Application by Beacon Fen Energy Park Ltd for an order granted development consent for the Beacon Fen Energy Park

Written Representation

**A report prepared by North Kesteven District Council
(ID F8D379496)**

Planning Inspectorate reference: EN010151

Figure 6.2 Screened Zone of Theoretical Visibility with Viewpoints

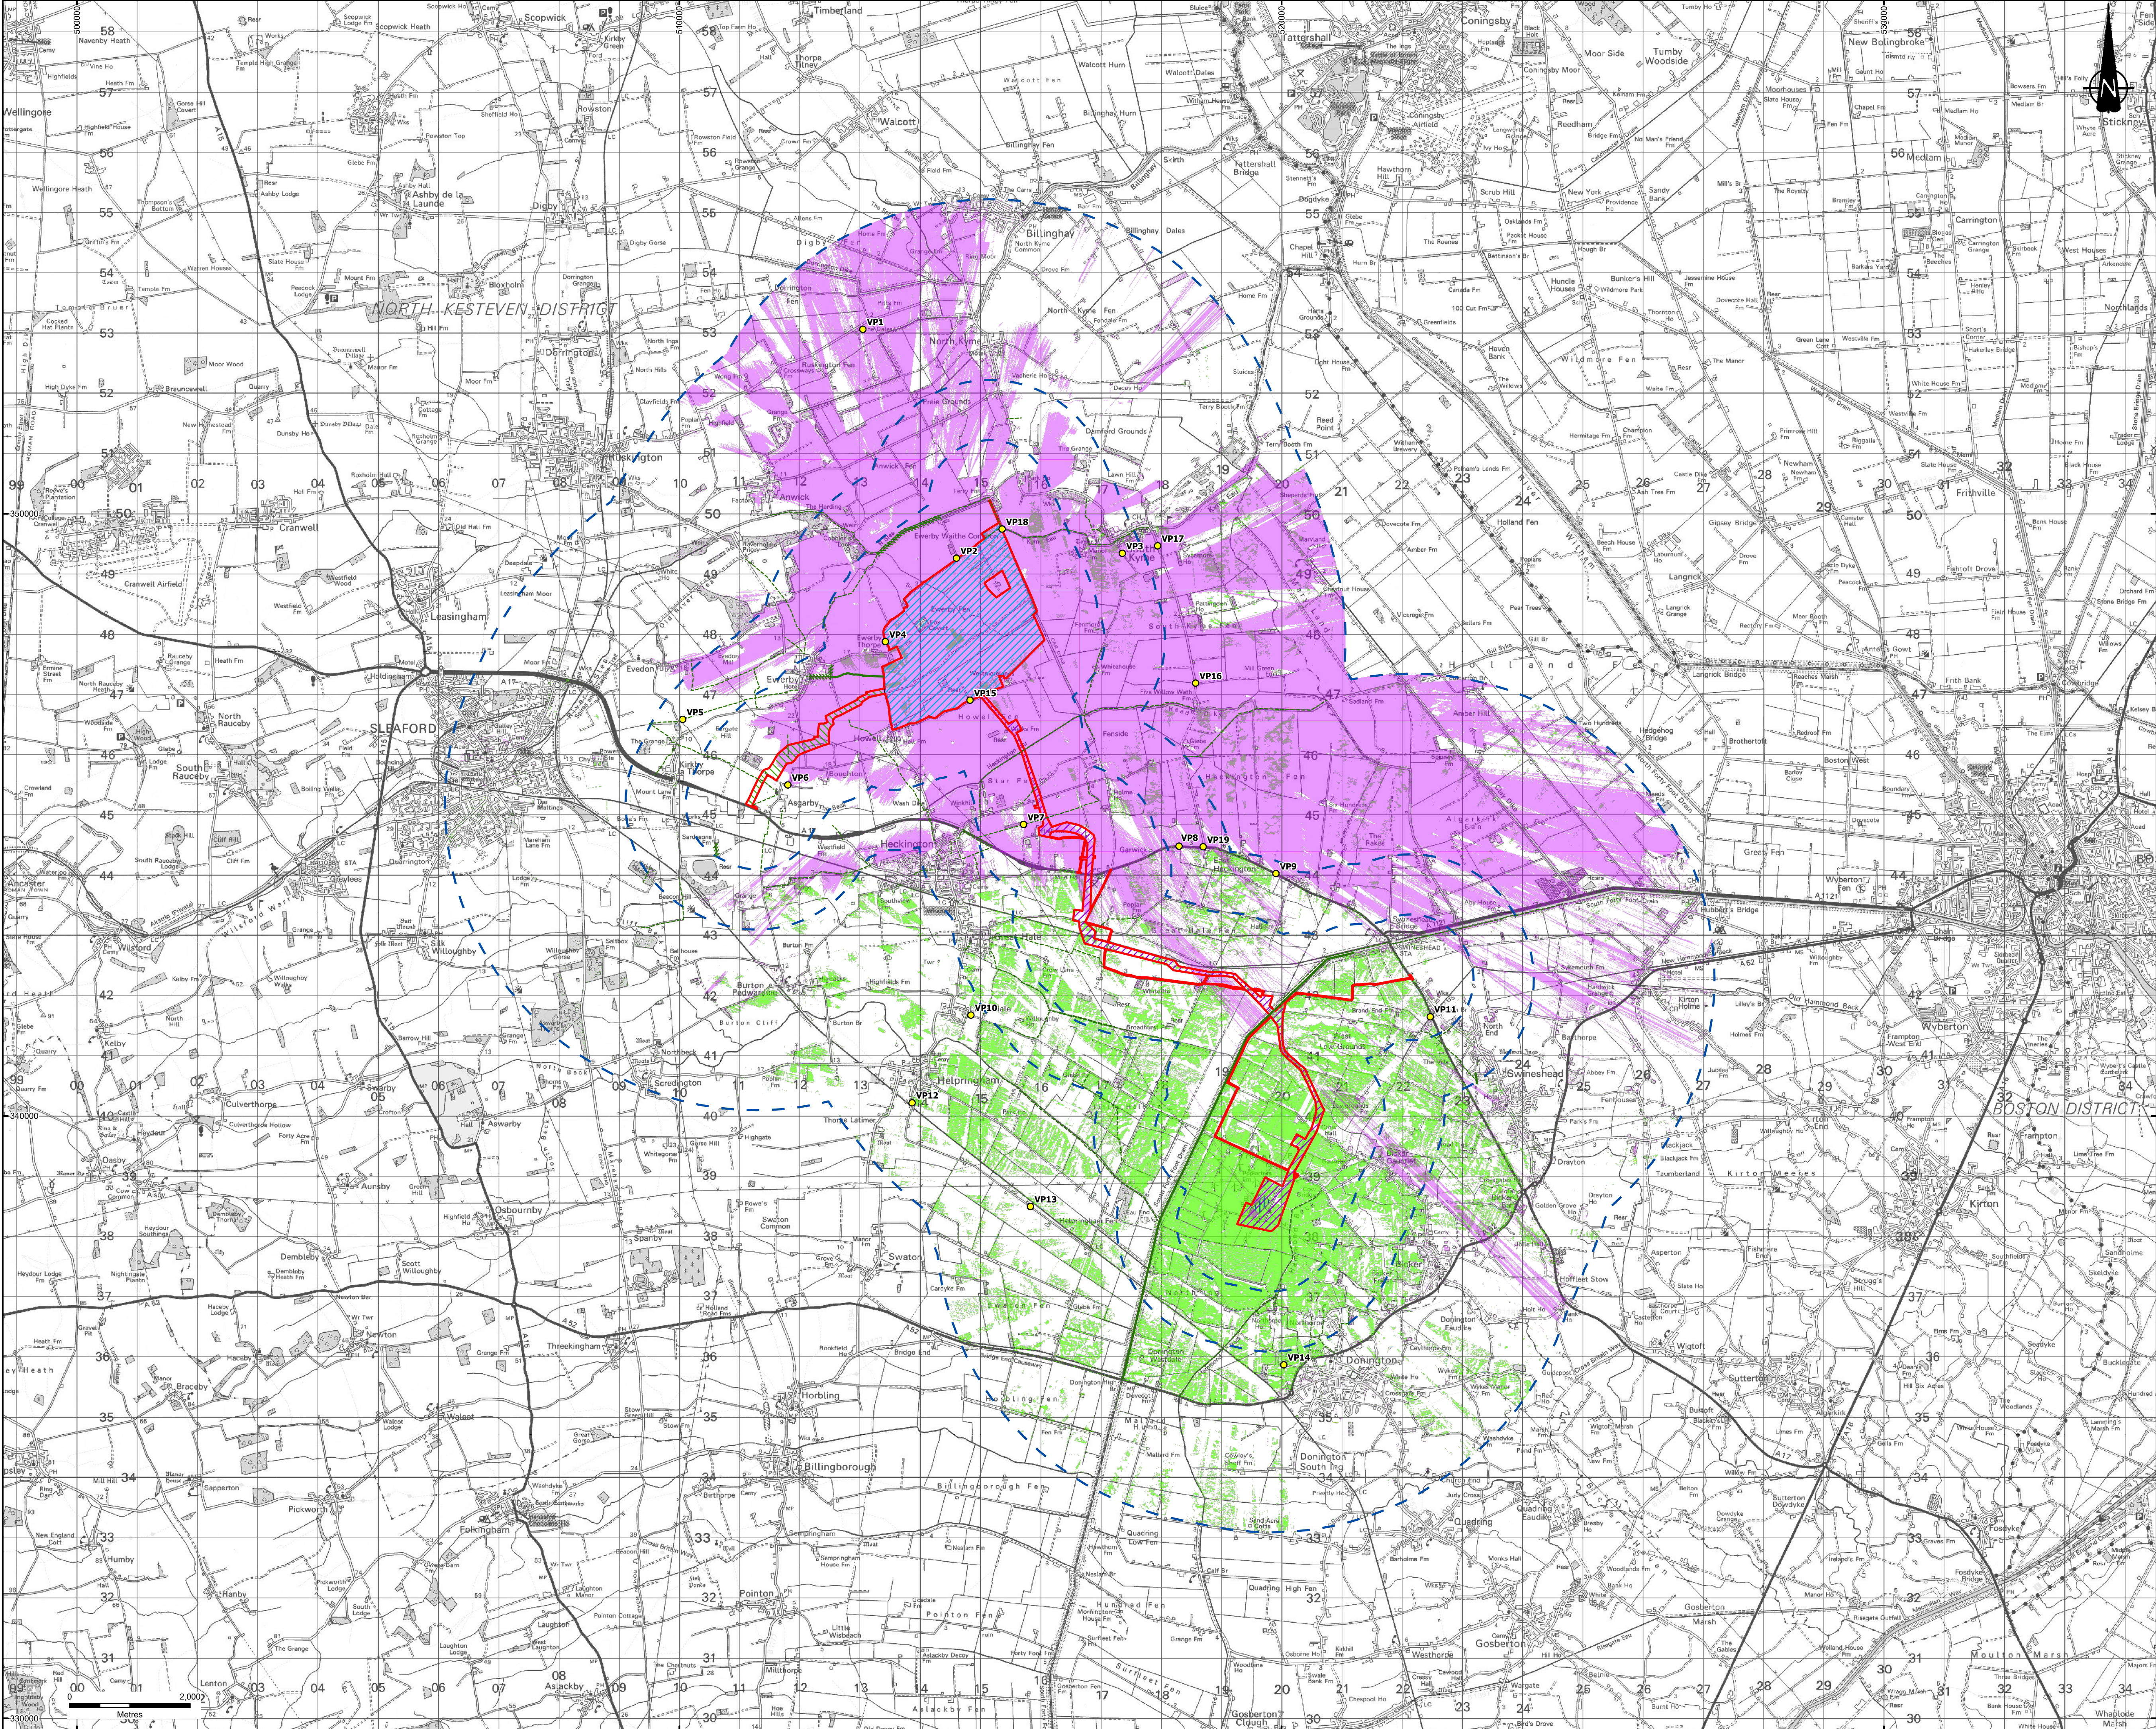
- 4.17 **AAH comments on Visual Impact:** The Visual Assessment is provided within section 6.6 of the LVIA and detailed within *Appendix 6.4: Visual Assessment*. As outlined above, AAH have not located an assessment of value or susceptibility relating to visual receptors, with only a final judgement of ‘Sensitivity’ of visual receptor provided within Appendix 6.4 with no explanation as to how this judgement has been arrived at.

- 4.18 The LVIA chapter does not provide any narrative in regard to the assessment to the value of views experienced by receptors or the susceptibility of receptors to changes in their view. While an assessment of sensitivity is provided within Appendix 6.4 of the baseline panoramas (viewpoints), none is provided for the receptors themselves. This does not fully align with guidance provided within the Landscape Institute’s *Technical Guidance Note LITGN-2024-01 ‘Notes and Clarifications on aspects of the 3rd Edition Guidelines on Landscape and Visual Impact Assessment (GLVIA3)’*.
